Application Ref:	3/2025/0889			 <p>Ribble Valley Borough Council</p> <p>www.ribblevalley.gov.uk</p>
Date Inspected:	07/01/2026	Site Notice:	18/12/2025	
Officer:	MC			
DELEGATED ITEM FILE REPORT:				REFUSAL

Development Description:	Erection of a part single-storey and part two-storey dwelling of exceptional design quality (NPPF 84e) with associated landscaping, habitat restoration, change of use of land to residential curtilage and access from Higher Road, together with the creation of a small visitor car park for members of the public to view the remains of the Roman road to be preserved within the site.(resubmission of application 3/2025/0095)
Site Address/Location:	Land at Higher Road Longridge PR3 2YX

Front (North) Elevation 1:100

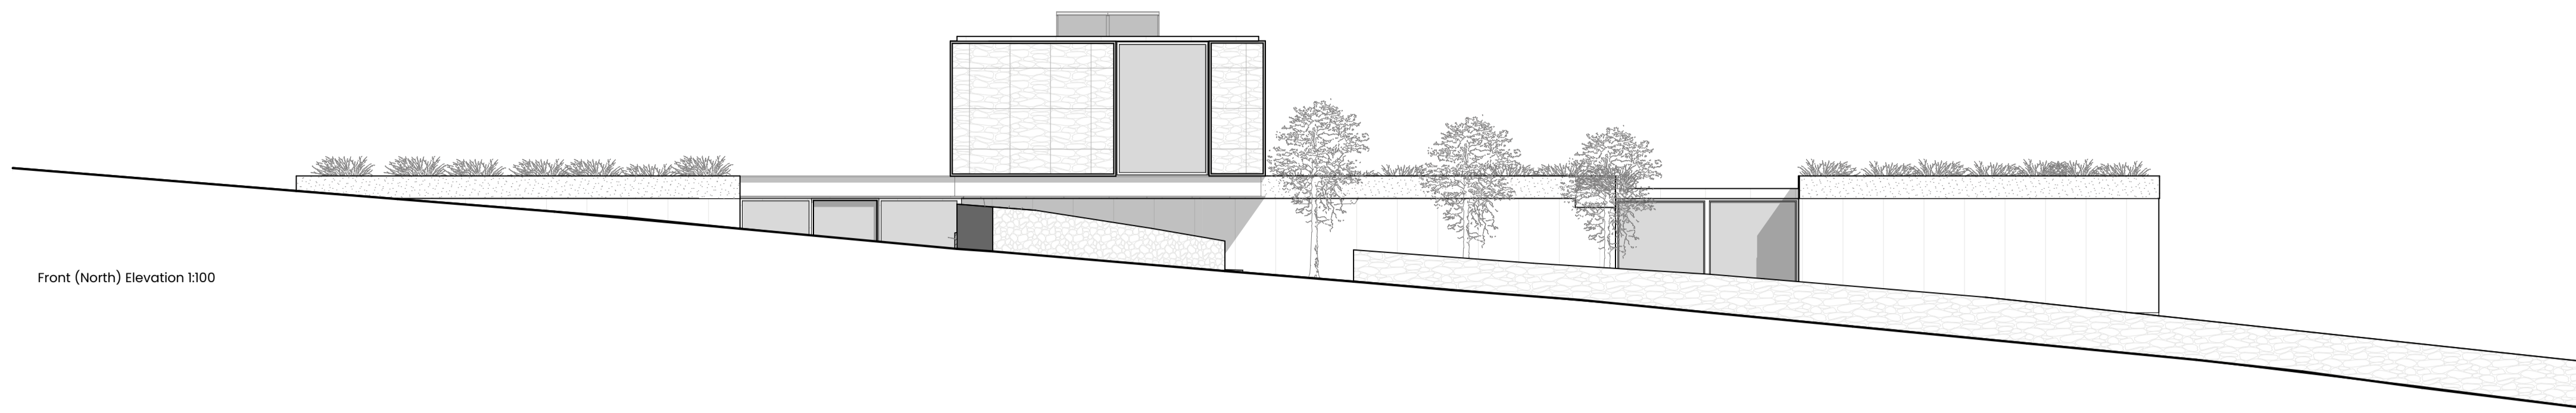
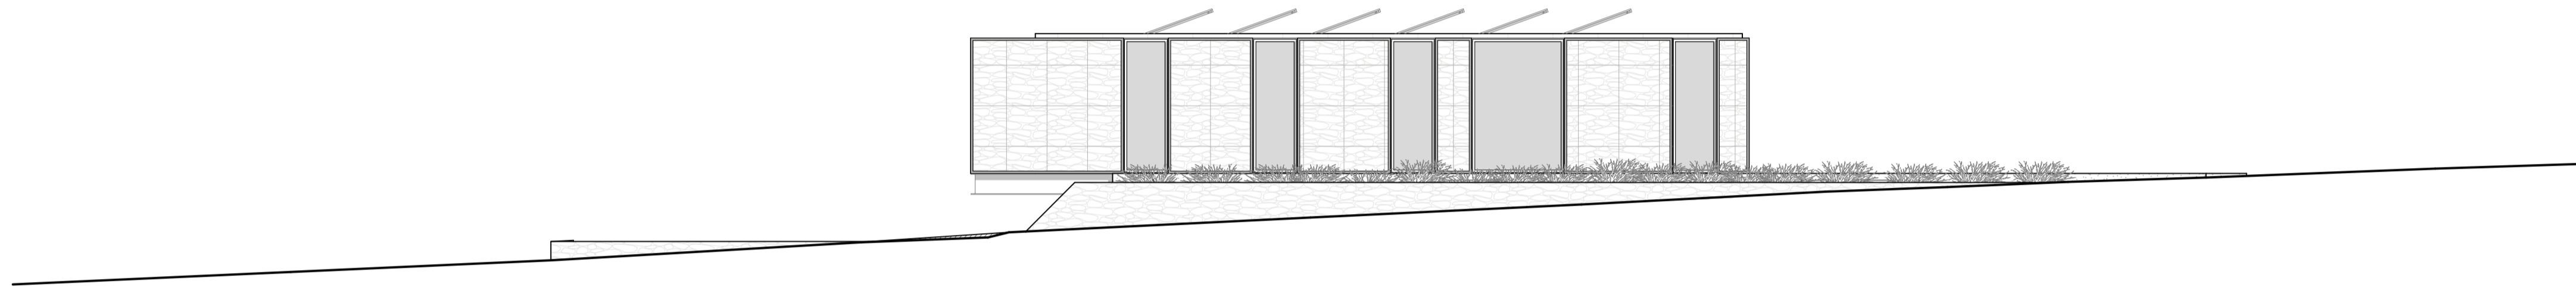
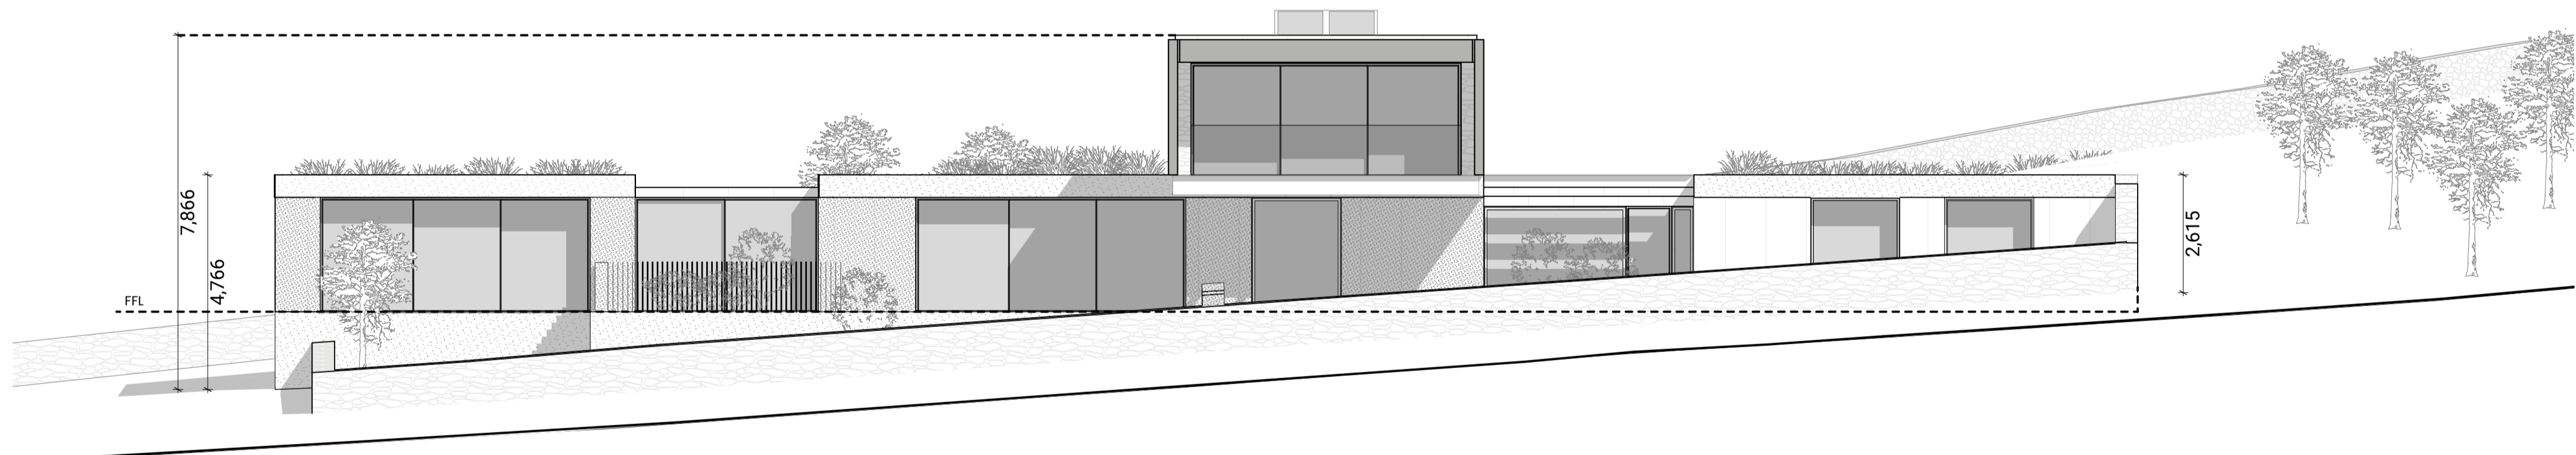
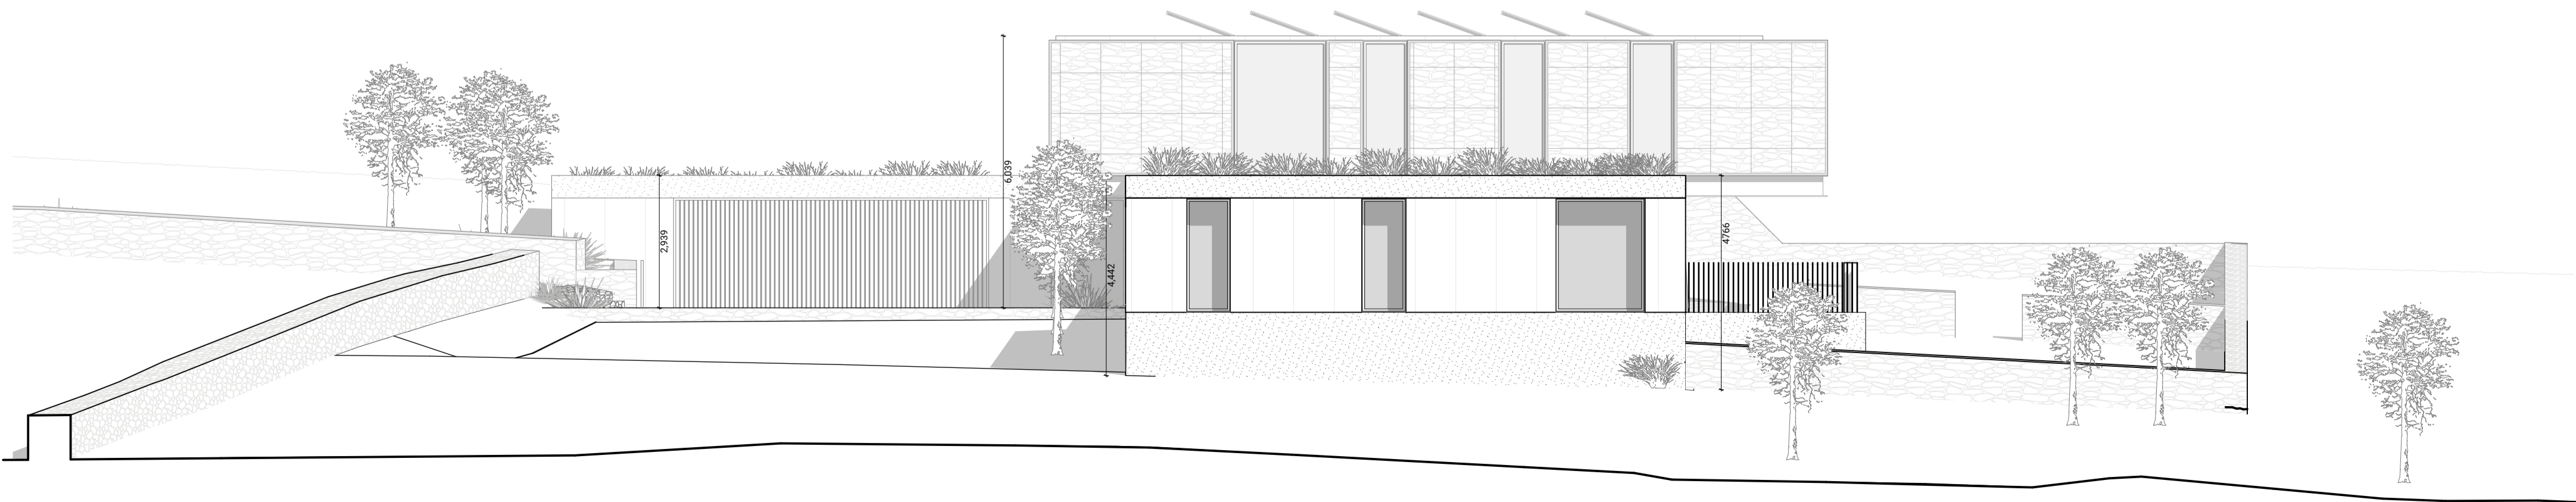
The delegated officers report for planning ref: 3/2025/0095 noted that the dwelling would be an overtly linear in its configuration, being of a contemporary flat-roofed appearance with a semi-cantilever first floor element. The report also made reference to the fact that elements of the proposed building would utilise the varying topography of the site with the eastern extents of the main body of the proposed structure being partially ‘dug-in’ to the existing topography. However, concerns were raised regarding views from the south which would result in the constructed of a raised floorplate platform which results in a somewhat overly-engineering arrangement and engineered response to the site characteristics.

The report also raised concerns that the overall architectural and elevational language of the ground floor is both stark and austere, lacking any visual devices or archetypes, save that for the fenestration arrangement,

that would afford the proposal an adequate level of depth, relief or visual interest, resulting in an overtly engineered appearance.

Other areas which do not appear to be 'outstanding' design are the proposed hard engineered walls which make up the roof of the garage area and appear overly dominant and take away from the significance of the more agricultural features of the dwelling such as the stone walls.
